Foundation Lutheran Church  
Traffic Impact Study  
EPC PCD File No. SF2321  
(LSC #S234300)  
October 9, 2023

## Traffic Impact Study

RE: Foundation Lutheran Church  
El Paso County, Colorado  
Traffic Impact Analysis  
EPC PCD File No.: SF2321  
LSC #S234300

Figure 2
Site Plan

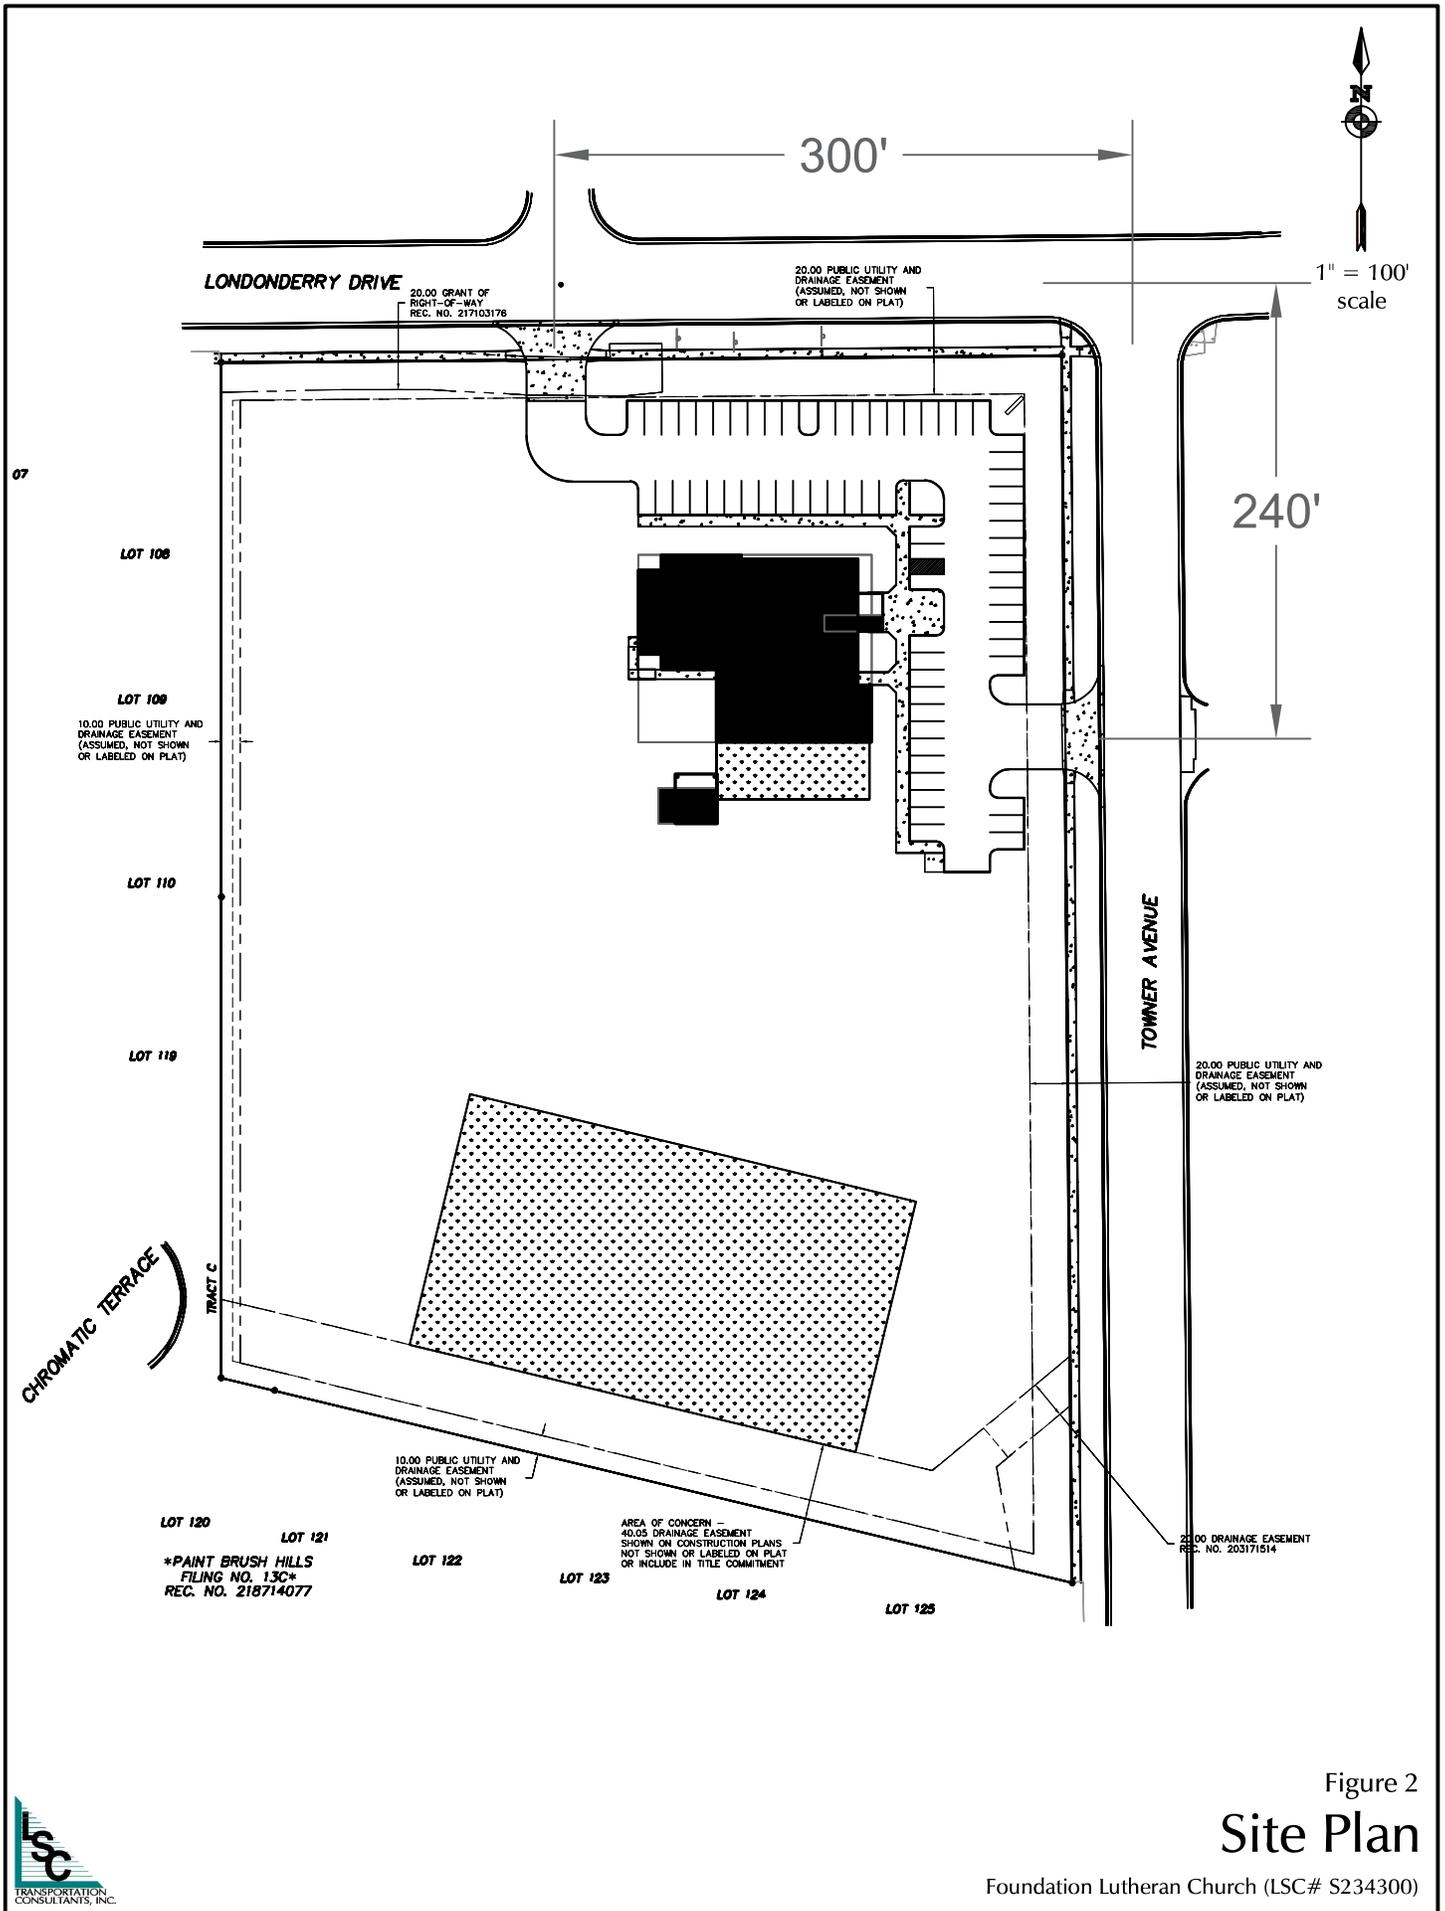
as these are driveways  
entering sight distance should  
be used instead of intersection  
sight distance

Address any line of sight impact from  
transformer location at the northern  
access point. This looks to need to be  
relocated both for line of sight and  
intersection design.

Figure 9

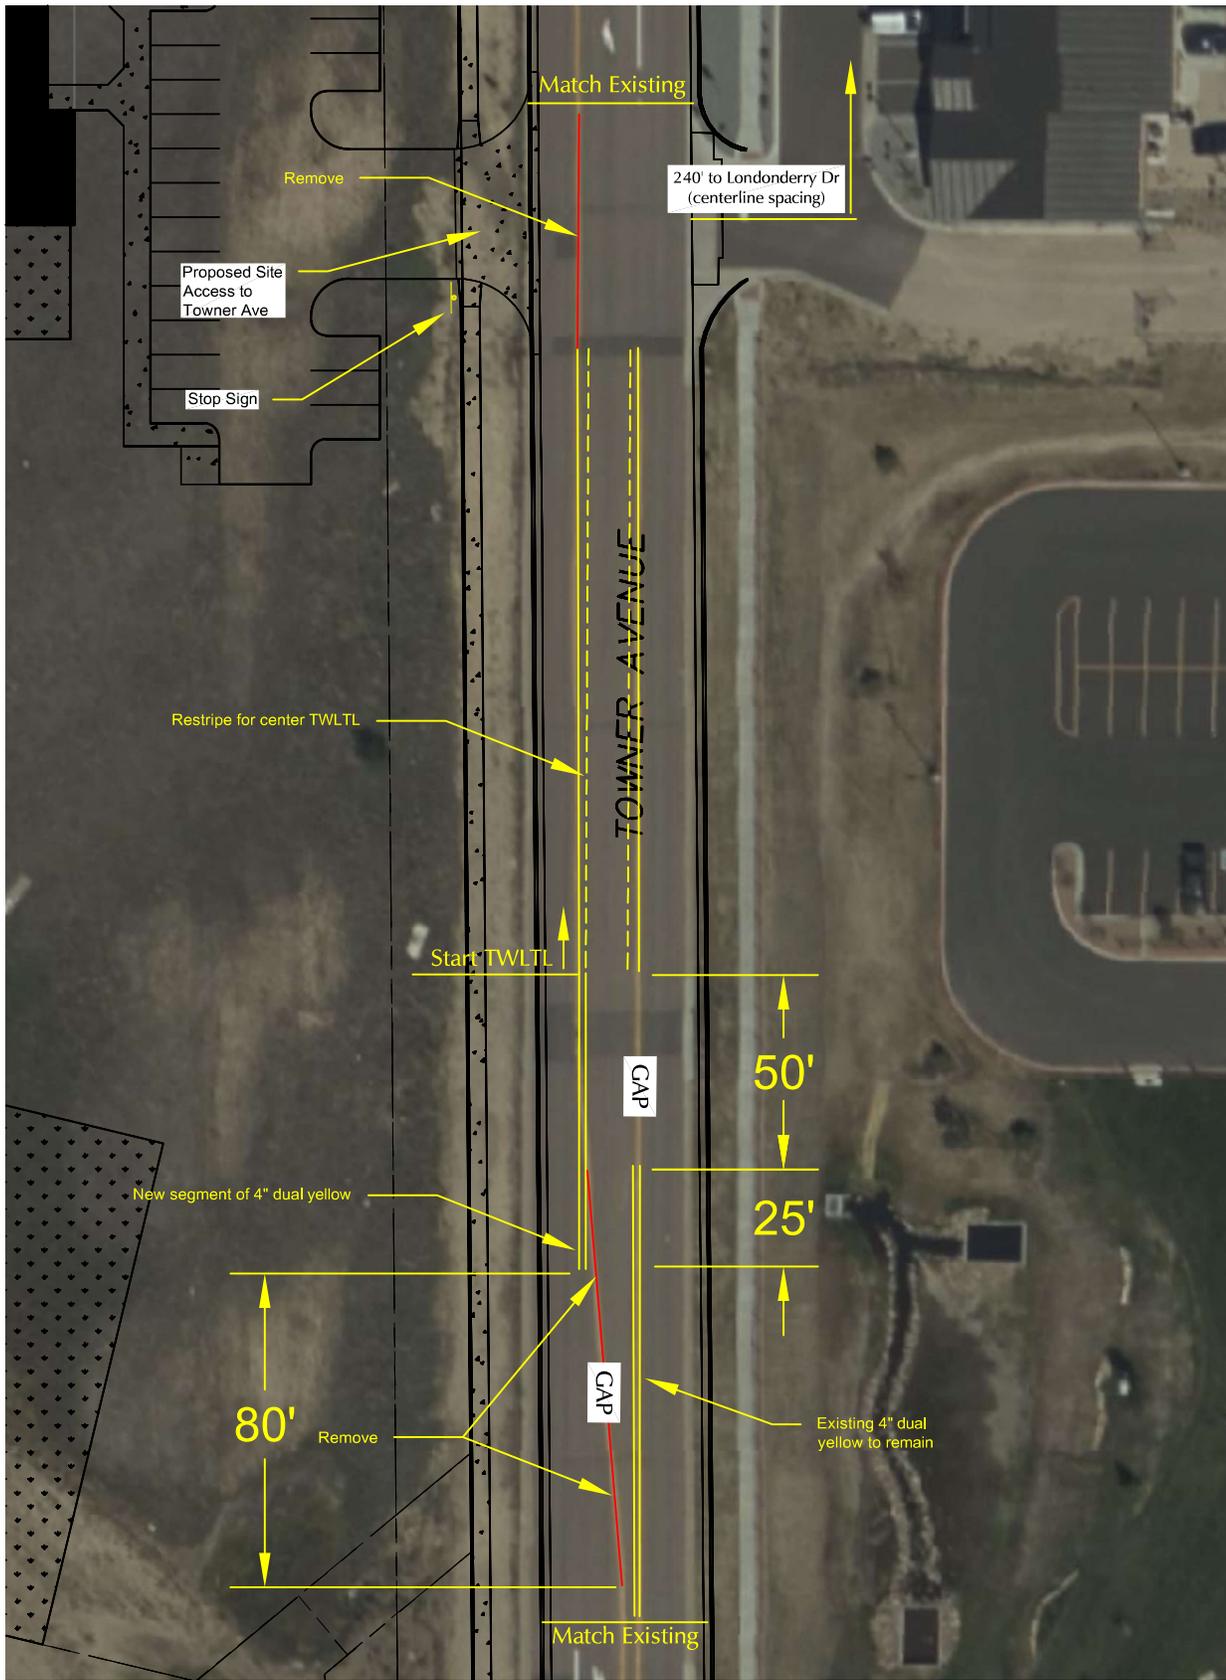
The Towner access point will be required to be restriped.

northbound left turns from Towner into the access driveway. A concept for the recommended restriping is shown in Figure 9.

Figure 10
 Left Turn Lane Concept
 Londonderry Drive/Triborough Tr./Site Access

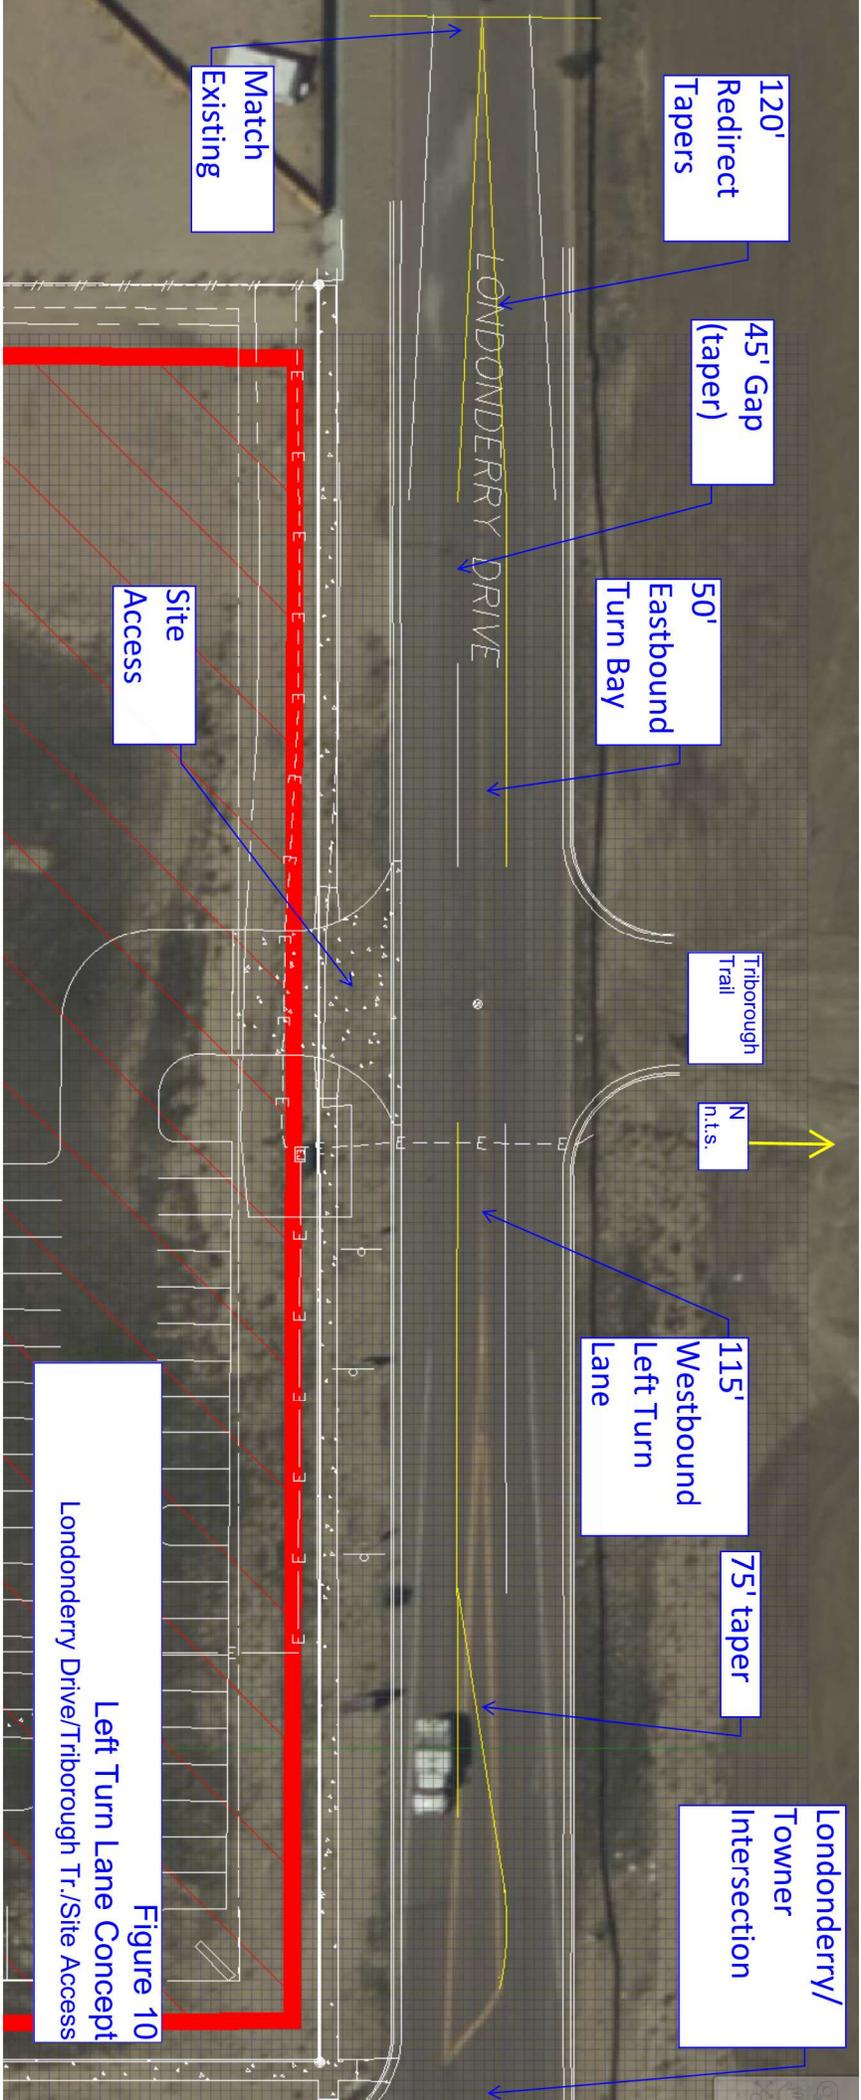
identify the lane length characteristics required per ECM and what is proposed. Volumes provided meet the threshold for turn lanes

A WB left turn lane will be required at the northern access point on Londonderry. Provide exhibit.
